Recommendation Report for Planning Permission for Works or Extension to a Dwelling

REF NO: R/121/19/HH

LOCATION: 35 Broadmark Lane
Rustington
BN16 2HH

PROPOSAL: Proposed single storey rear extension and conservatory

ama architectural & quantity surveying services			
address of works: 35 Broadmark Lane, Rustington			
Drawing title: Proposed Rear Extension			
Date: Apr. 2019	Scales: As shown	Paper size: A3	Dwg No.: AD-140-04

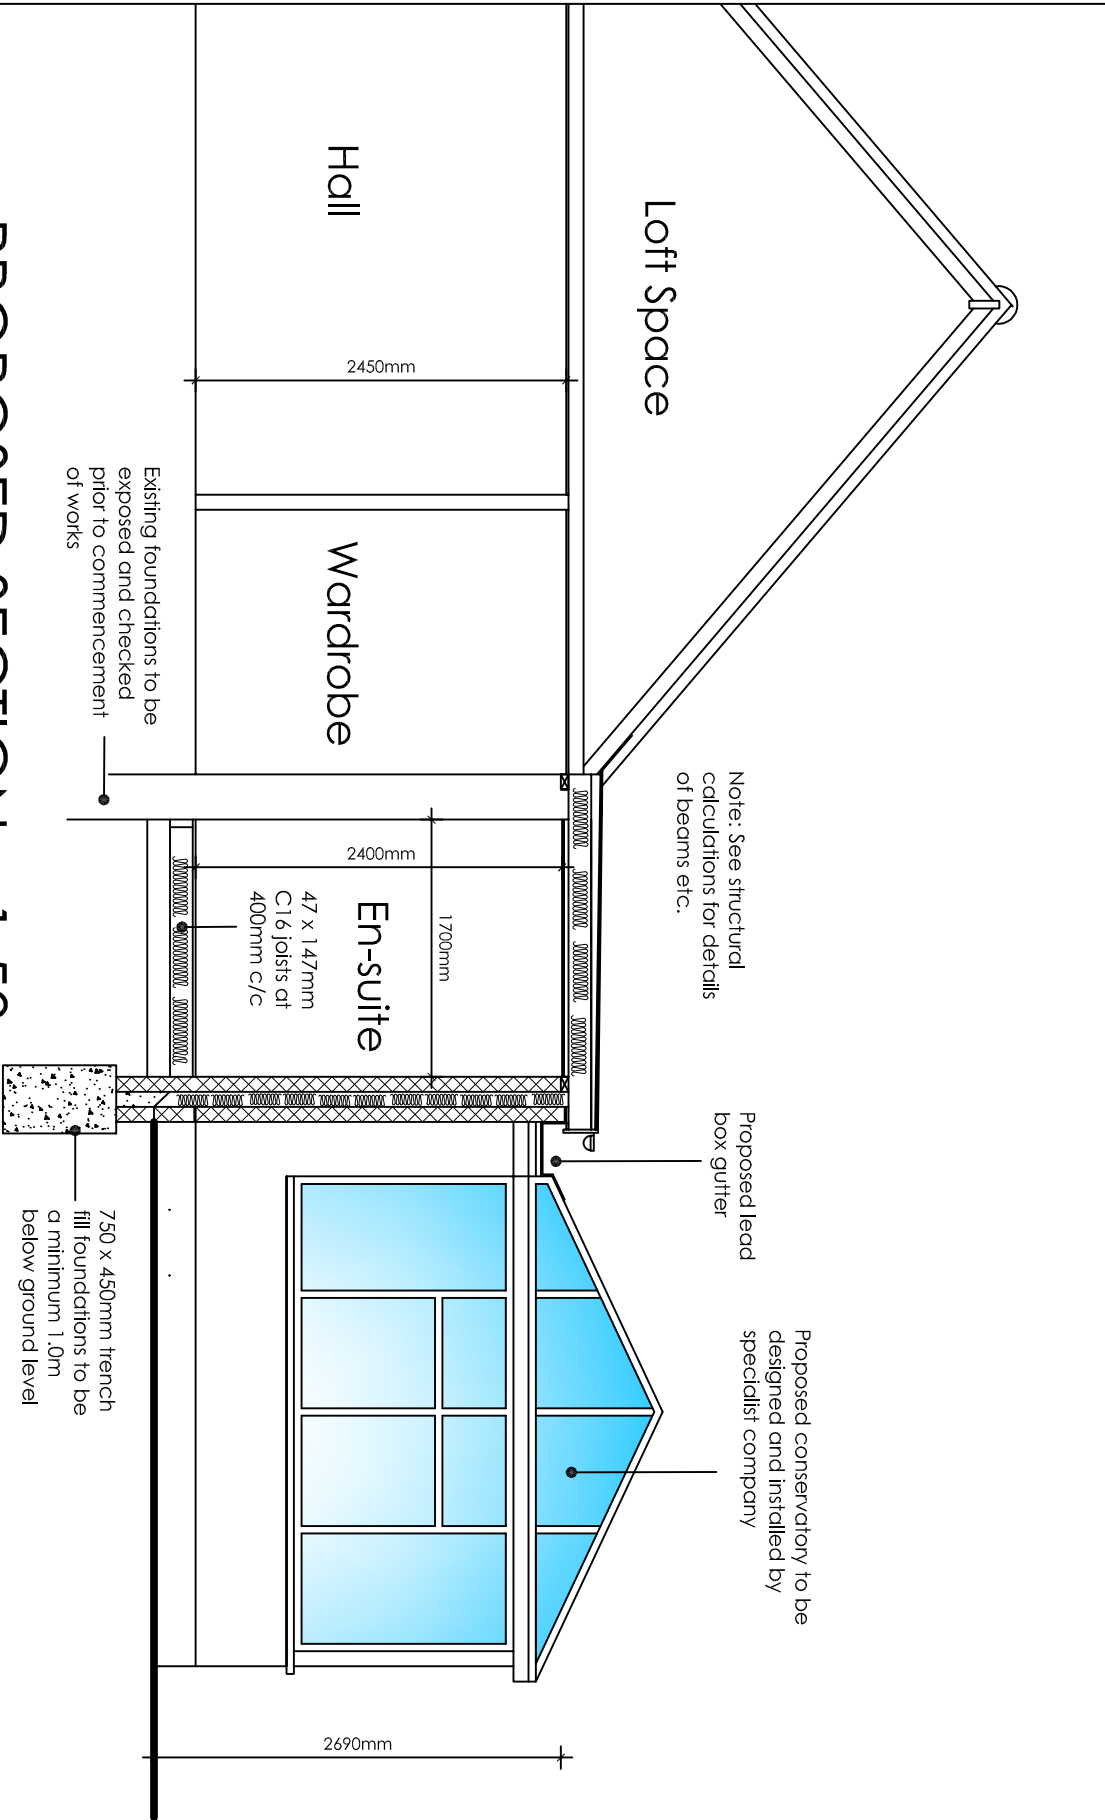
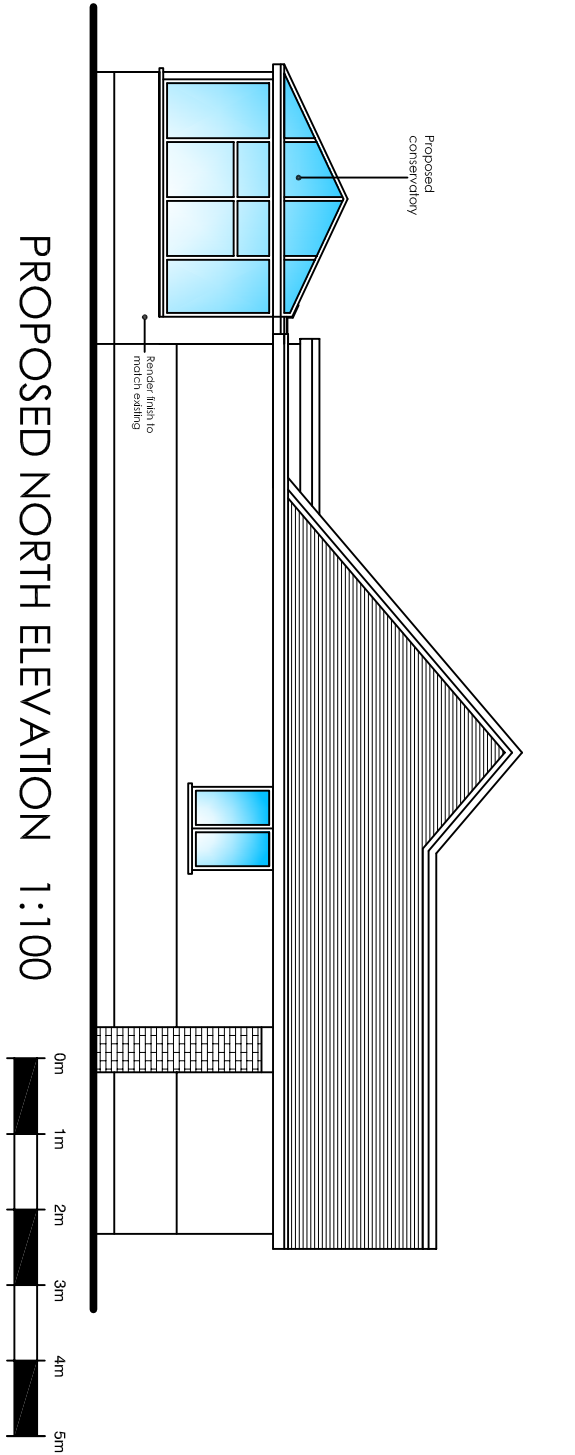
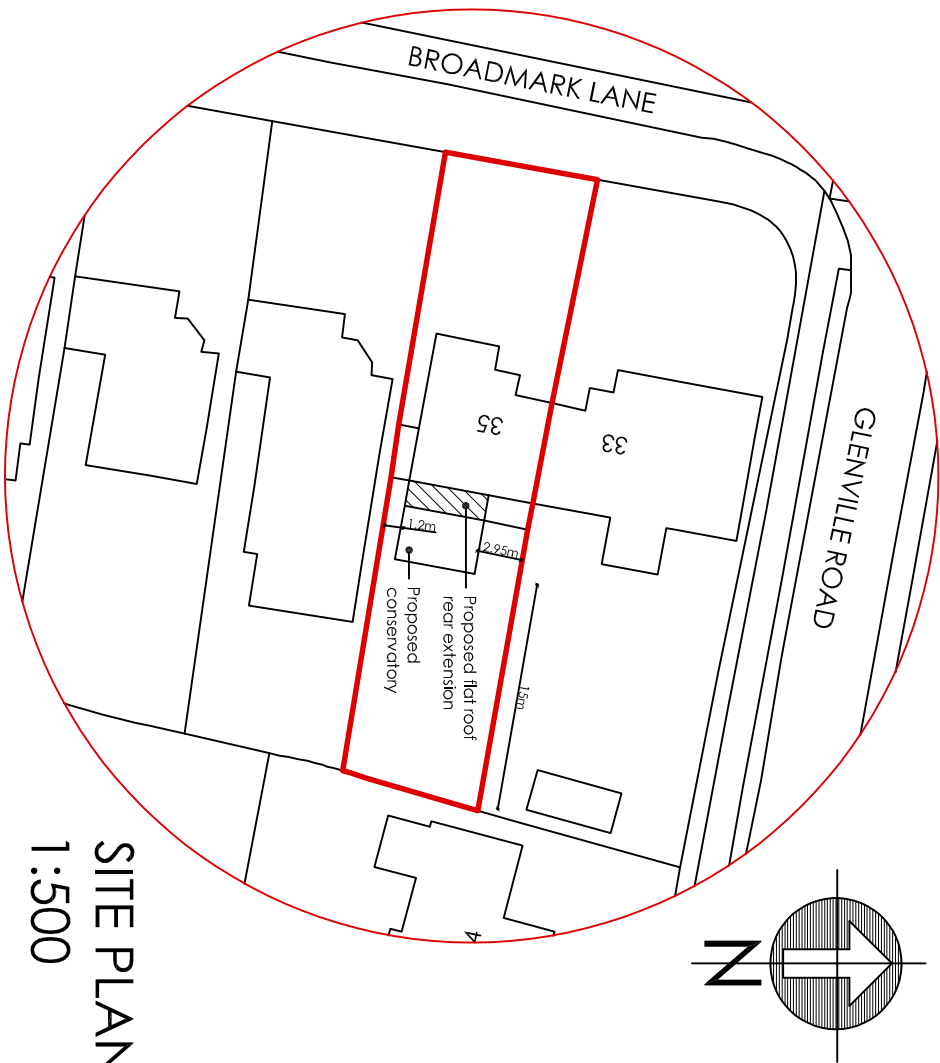
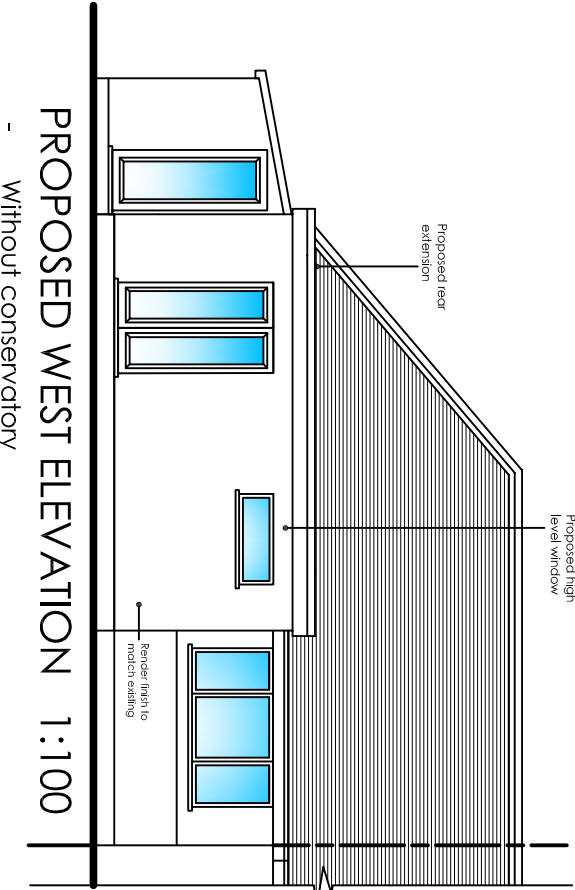
The applicant seeks planning permission for the construction of a rear extension and conservatory to the dwelling. The proposed rear extension will measure approximately 5.5m wide, 2m in depth and be built to the proposed height of 2.9m. The proposed conservatory will be measuring a further 3.9m in length, the same width as the extension as they are adjoining and to a proposed height of 3.35m and at the eaves 2.4m.

Given the design and location of the extension it is not considered to give rise to adverse impacts in terms of overlooking, overshadowing and overbearing as the total height of the proposed would not be clearly visible from the neighbouring property and is therefore deemed to accord with D DM1 and D DM4 of the Arun Local Plan.

Although this application will be the first in the area to have a pitched roof to the front of the dwelling on an extension it is not deemed to be detrimental to the character of the area or the spatial pattern of the road.

- 2 The development hereby approved shall be carried out in accordance with the following approved plans AD-140-03 and AD-140-04.

Date: Apr. 2019 Scales: As shown Paper size: A3 Dwg No: AD-140-03

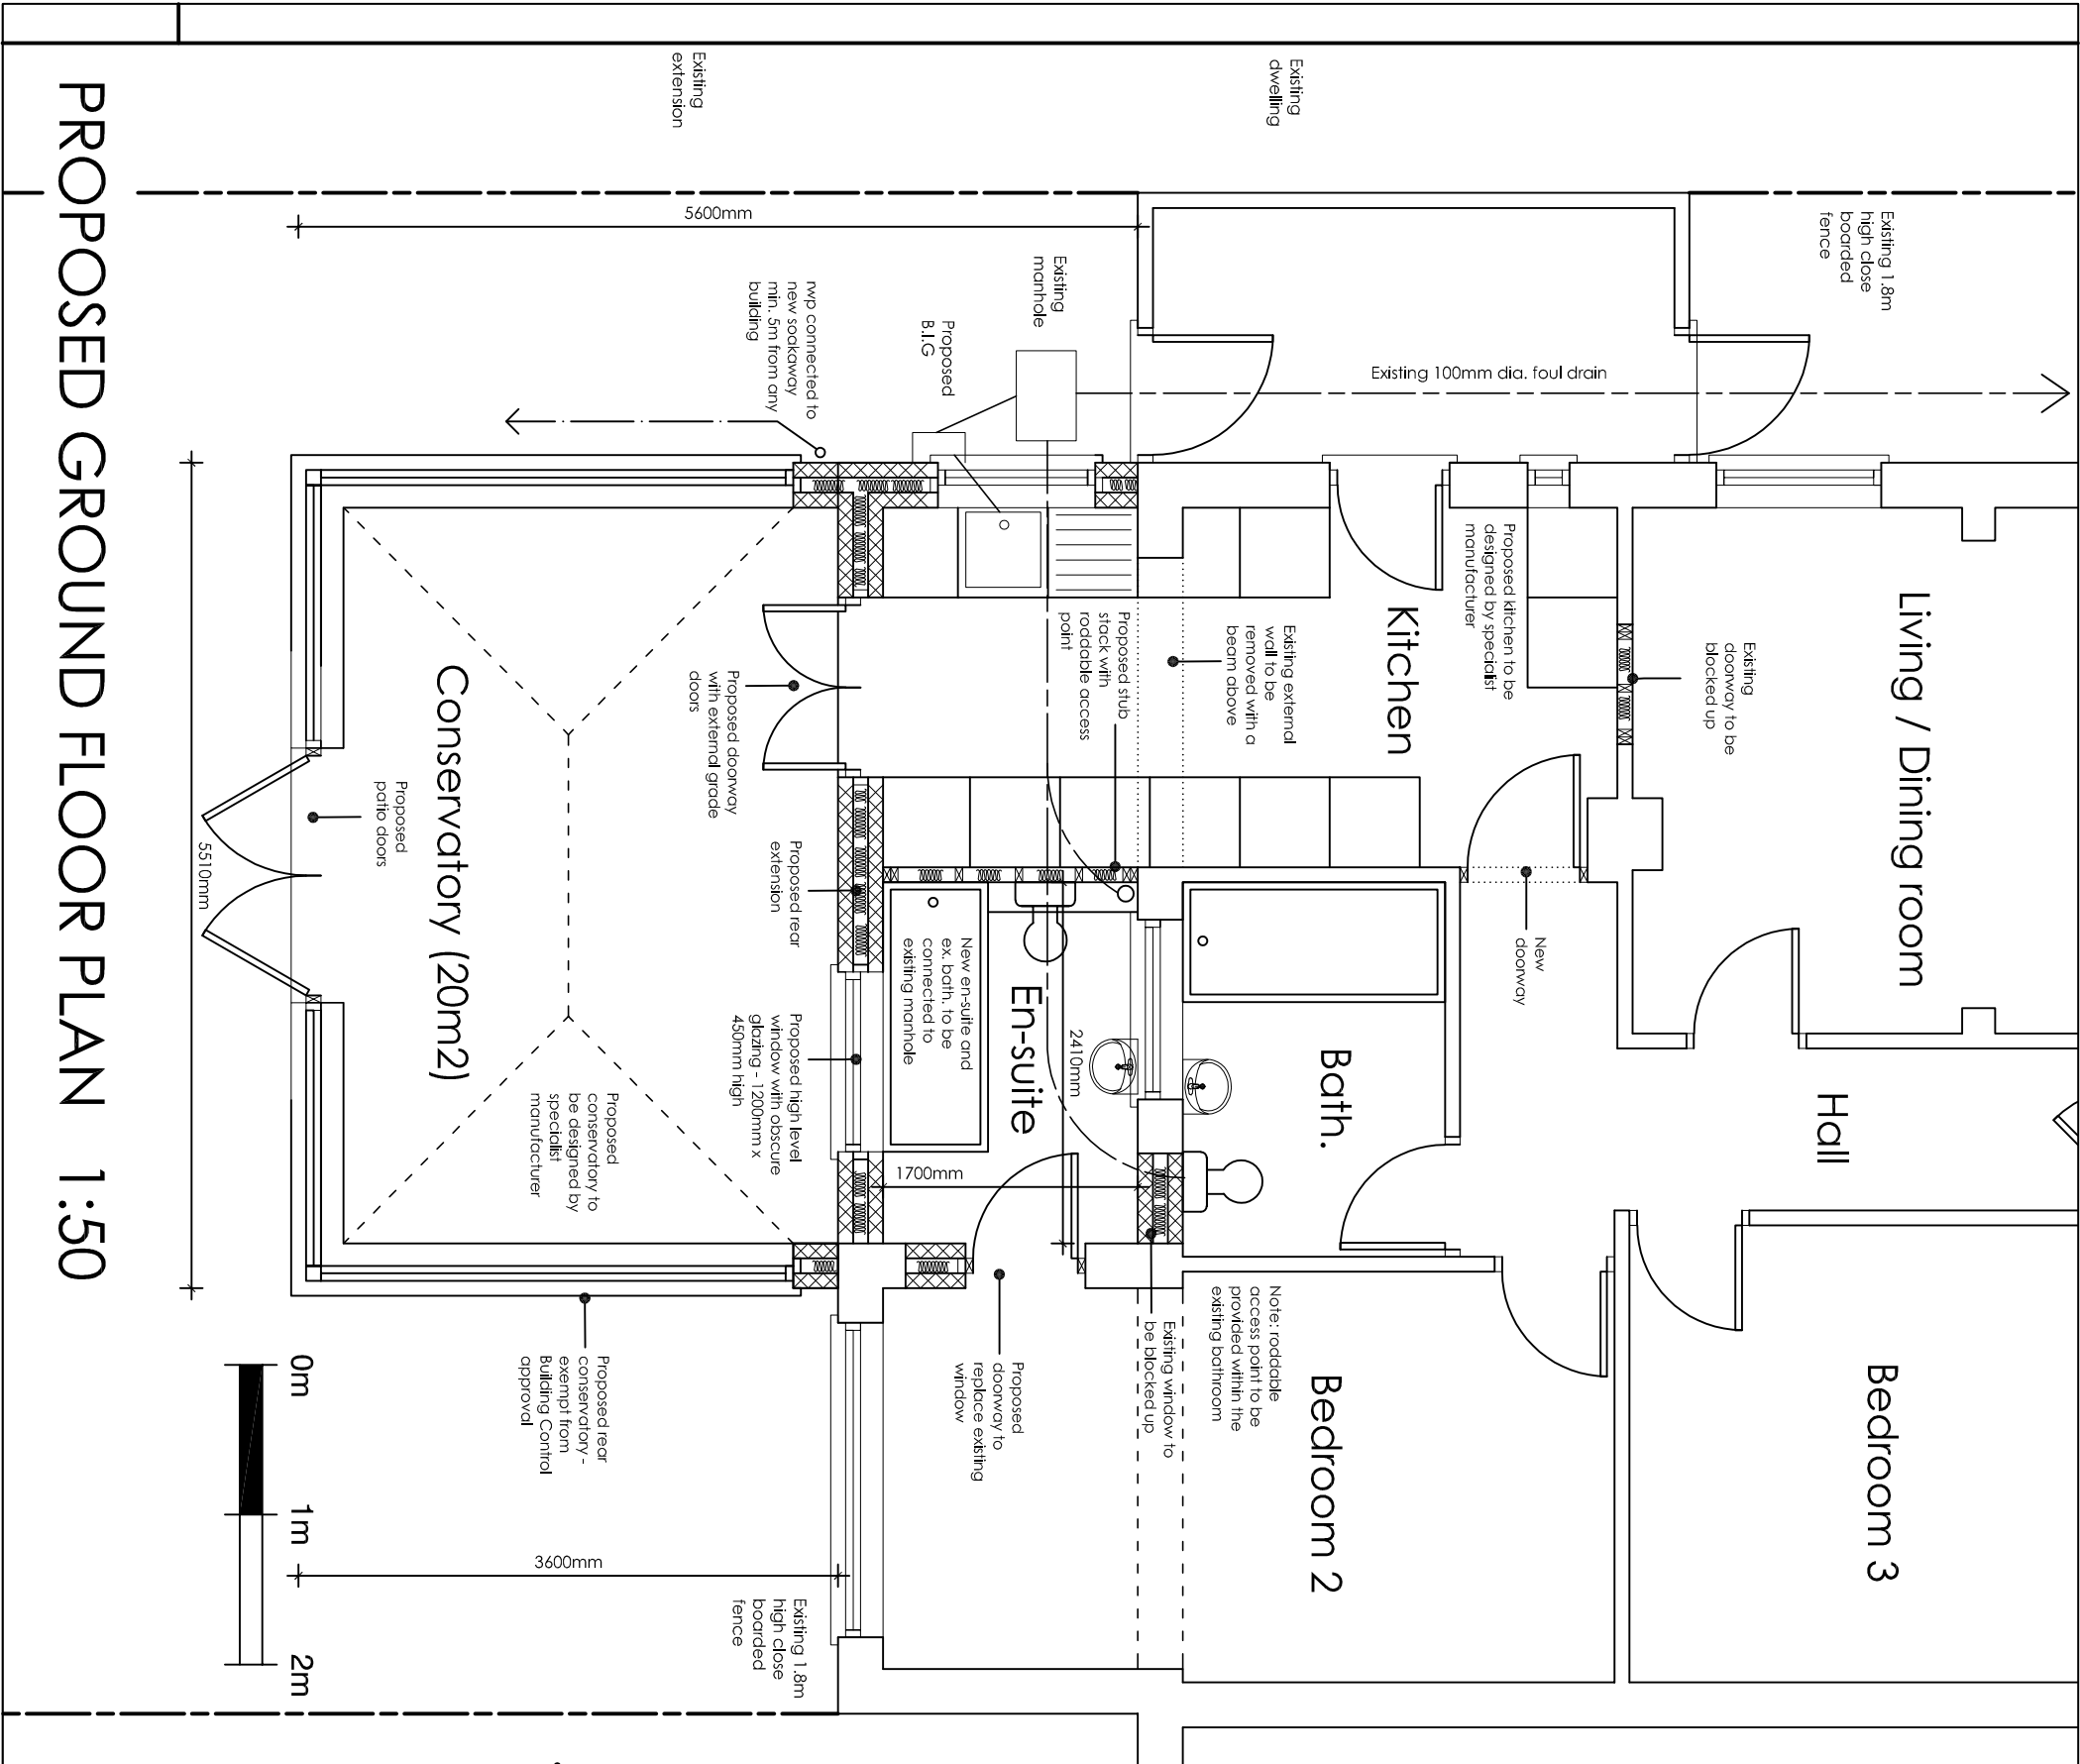
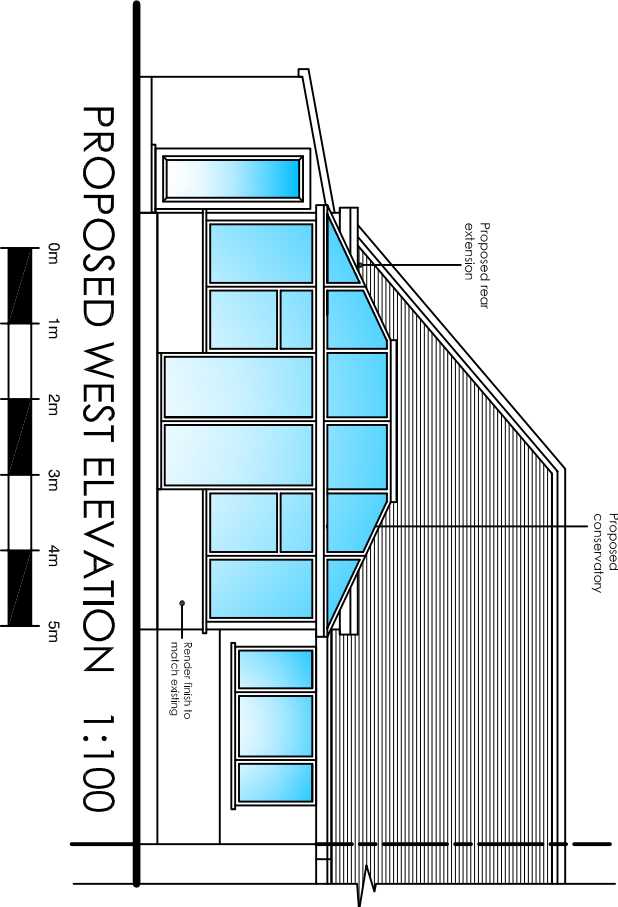
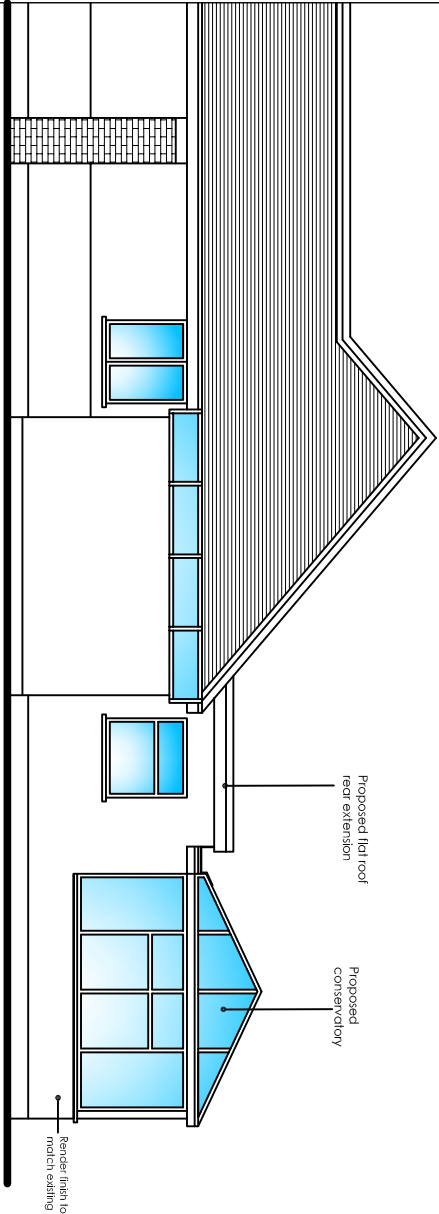
The proposed rear extension will be located approximately 14.6m from the eastern boundary, 1.2m from the southern boundary and 2.95m from the northern boundary.
